Our ref: AC/2021/130634/02-L01
Your ref: TR010044
Date: 14 January 2022

A428 BLACK CAT TO CAXTON GIBBET ROAD IMPROVEMENT SCHEME THE EXAMINING AUTHORITY'S 3RD WRITTEN QUESTIONS

Thank you for your correspondence regarding the above mentioned scheme. Our answer to your questions are provided below.

SEE SHEET 6

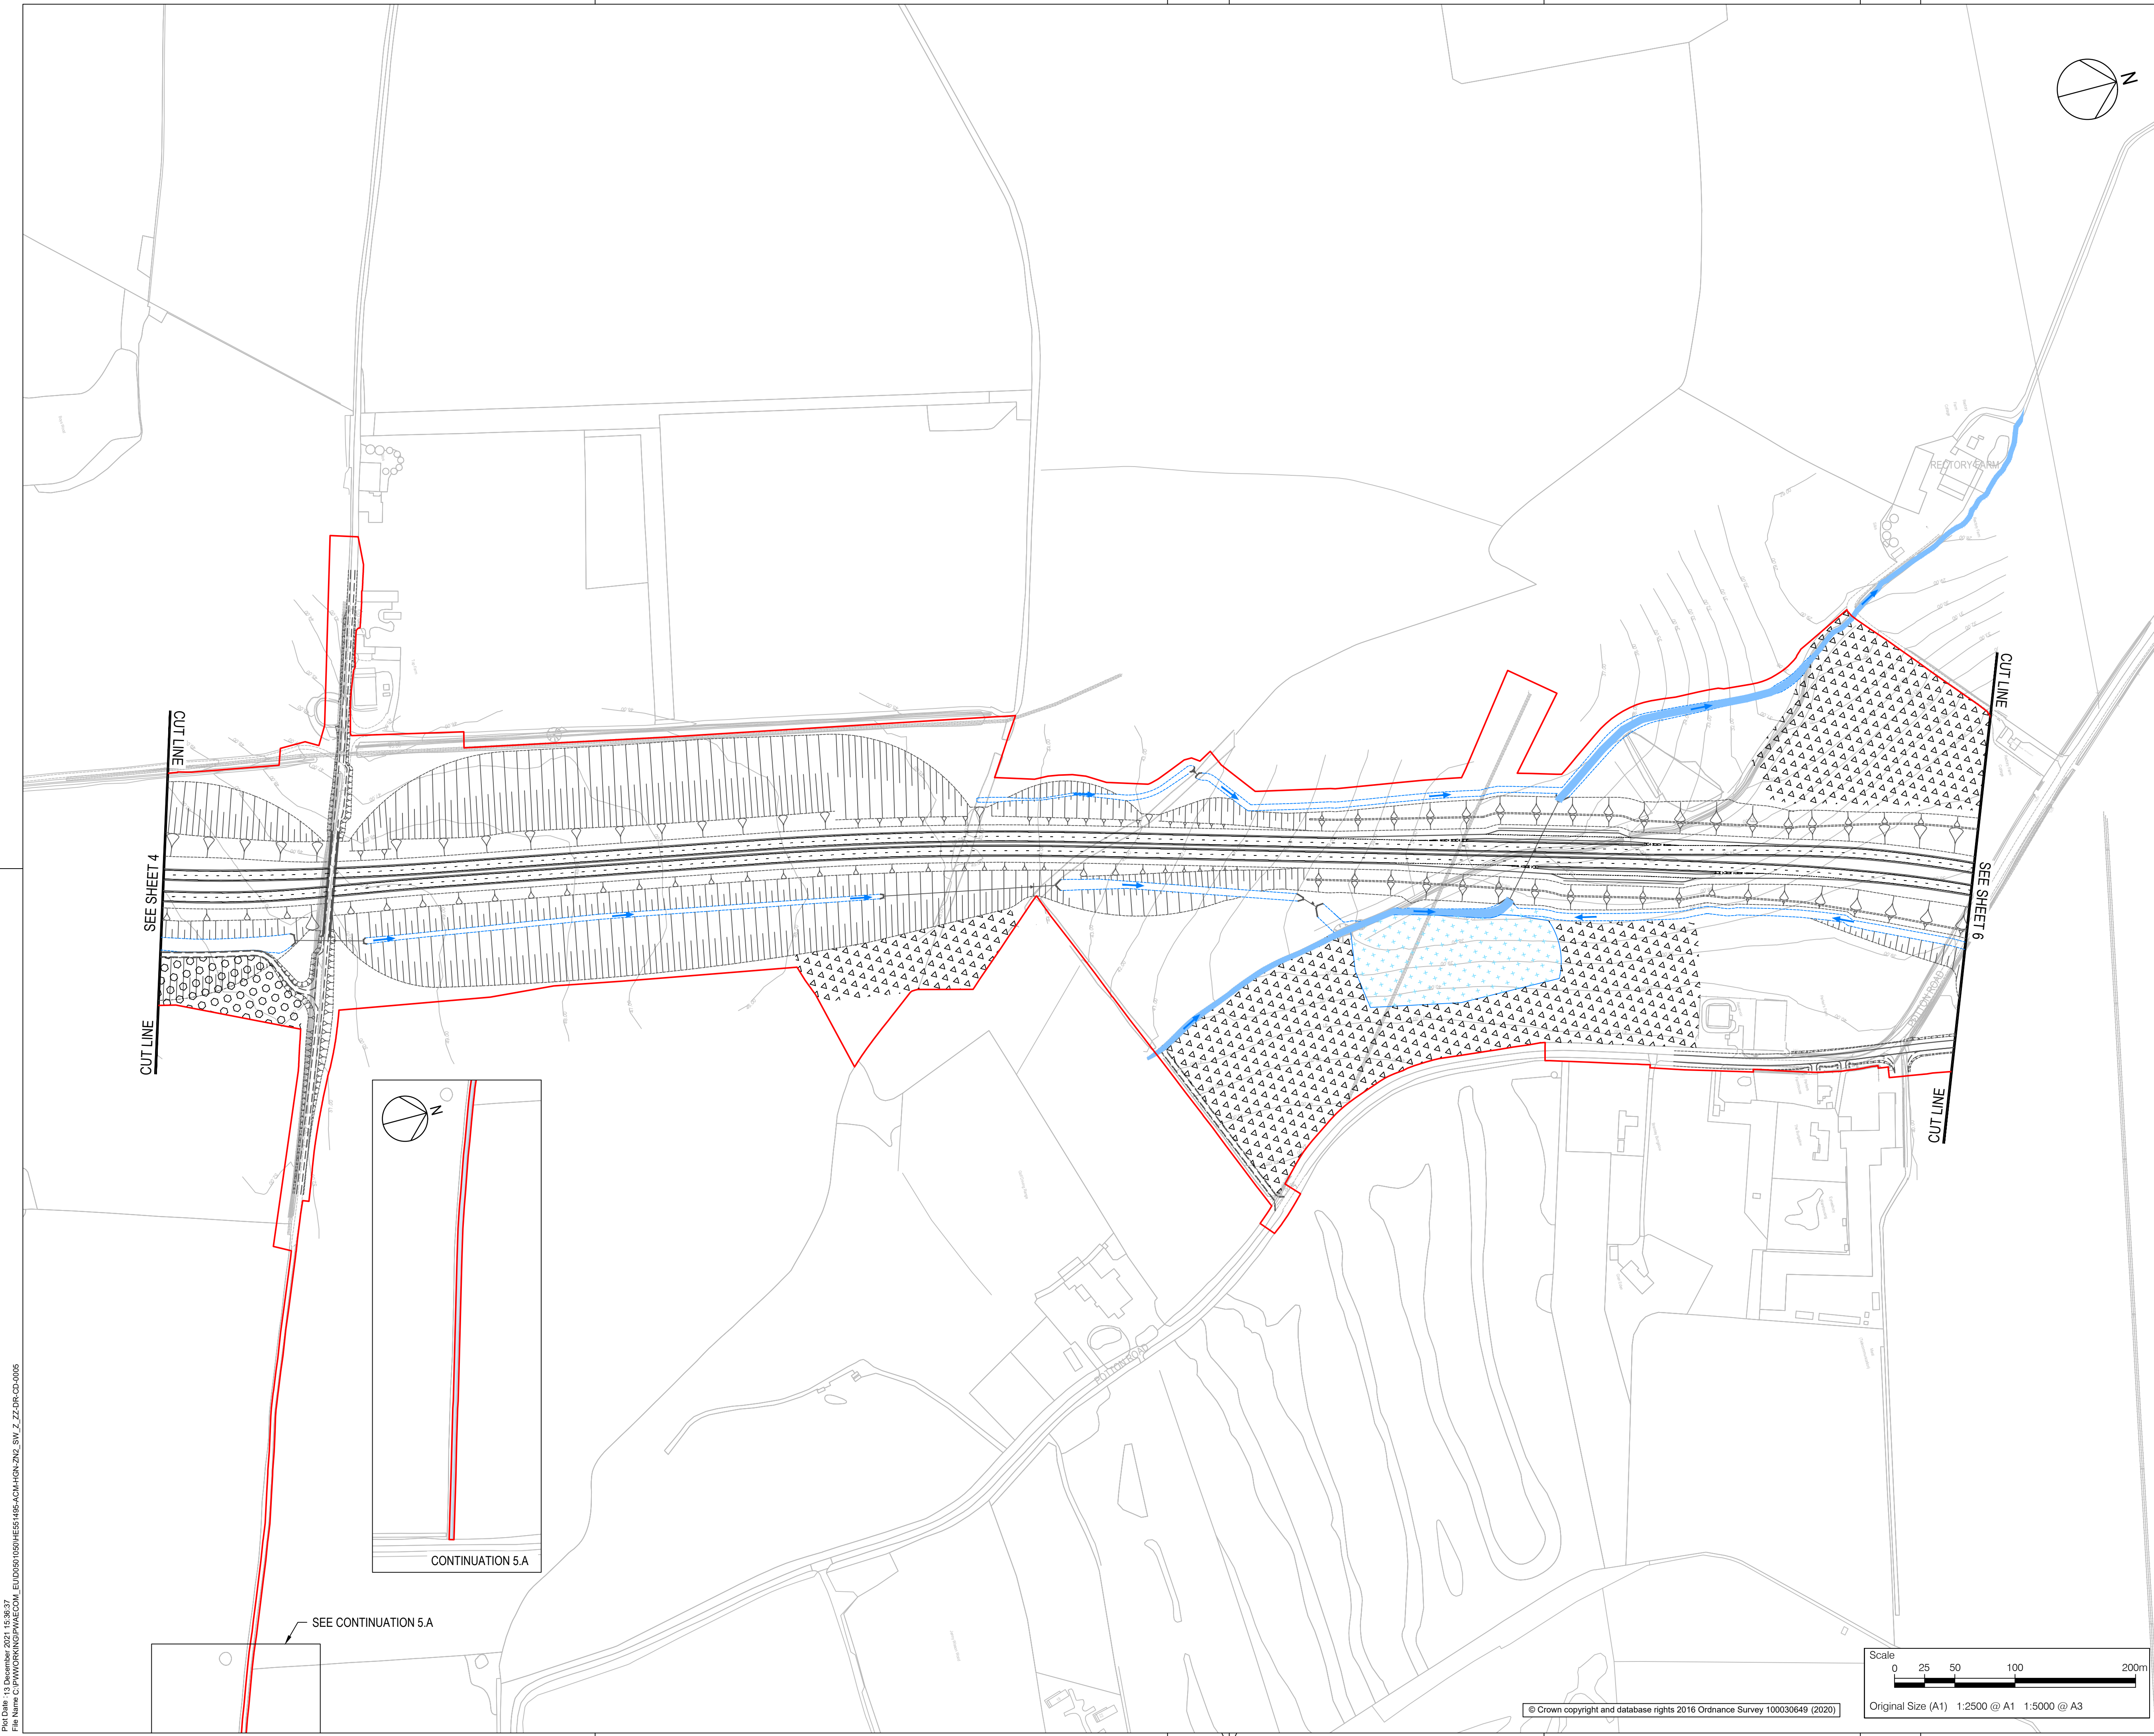
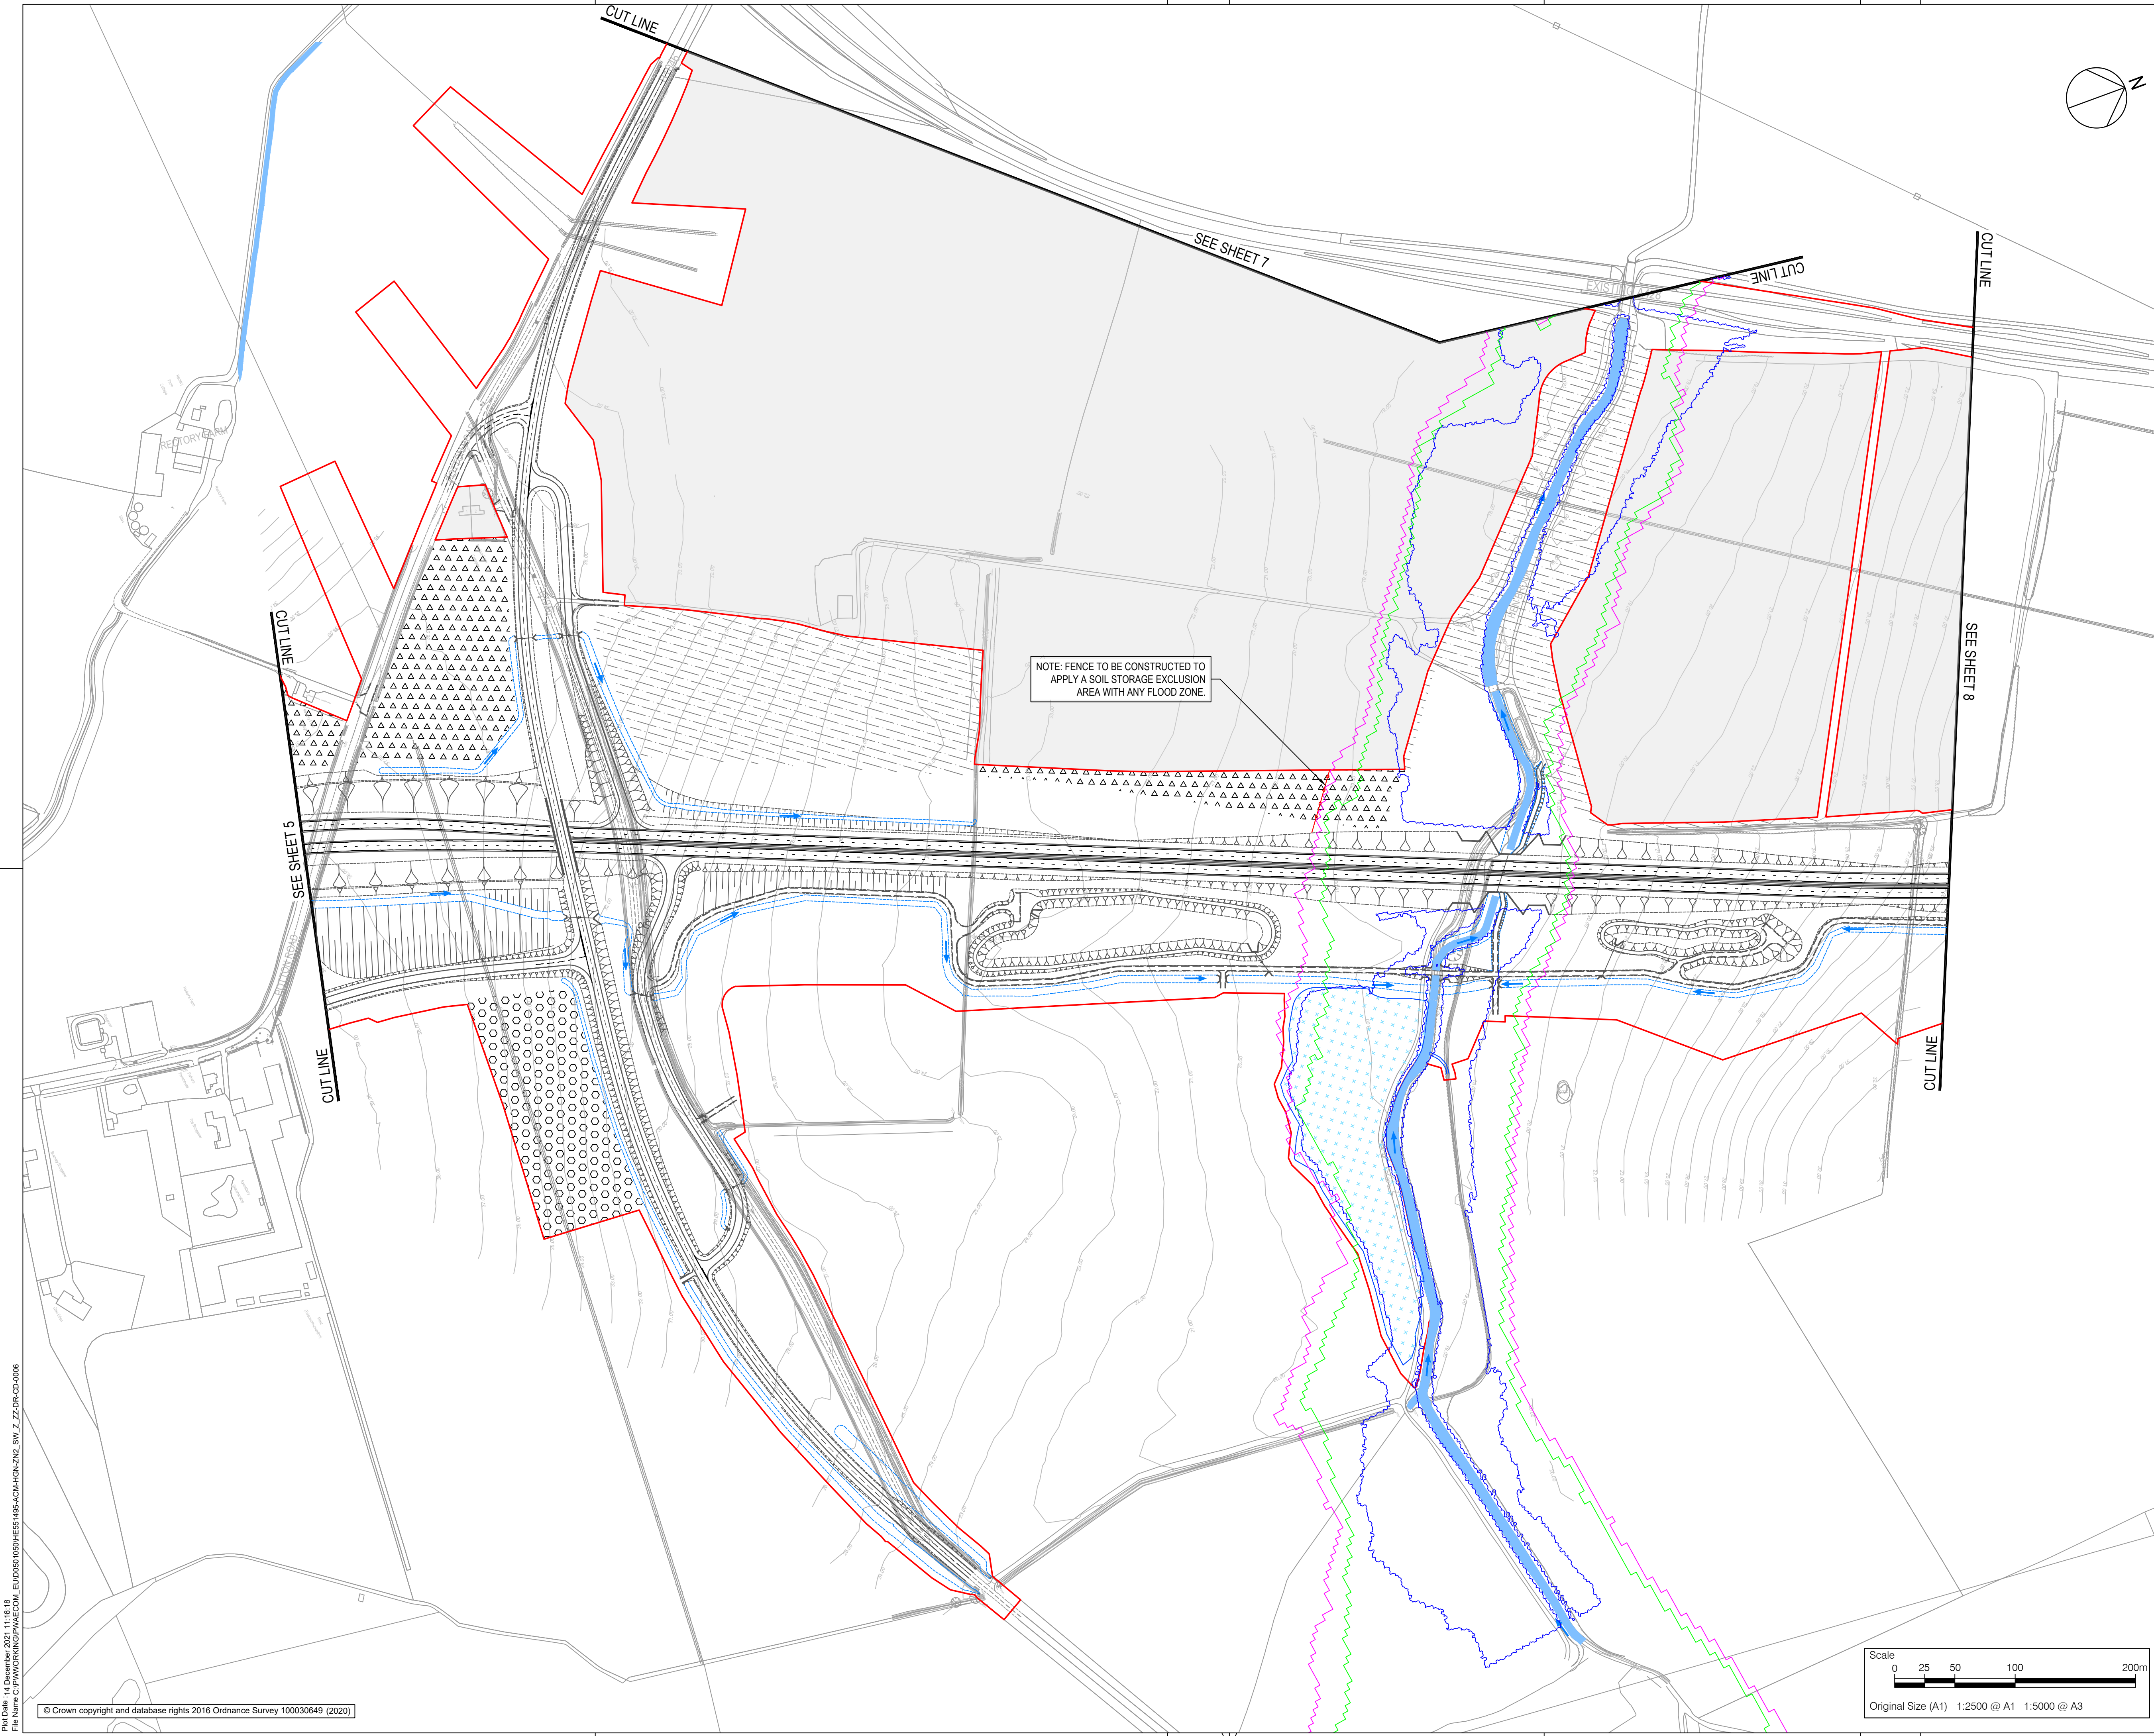
Given that one of the site compound areas is shown to be located entirely within Flood Zone 3 in Appendix B of the FRA Technical Note dated December 2021, we would like the First Iteration EMP to include some mitigation measures in relation to this to ensure there is no increase in flood risk elsewhere during the construction phase.

The First Iteration EMP (sections 1.737, 1.738, 4.2.28 and 4.2.29) states that no hazardous materials (COSHH) will be located in Flood Zone 3 (area at highest risk). However, Appendix B of the Flood Risk Assessment (FRA) Technical Note dated December 2021 still shows a number of site compound and soil storage areas within Flood Zone 3 and some of these are immediately adjacent to watercourses where we would expect flood water to regularly flow and be stored. We therefore consider that no soil storage areas or site compounds should be located within Flood Zone 3.
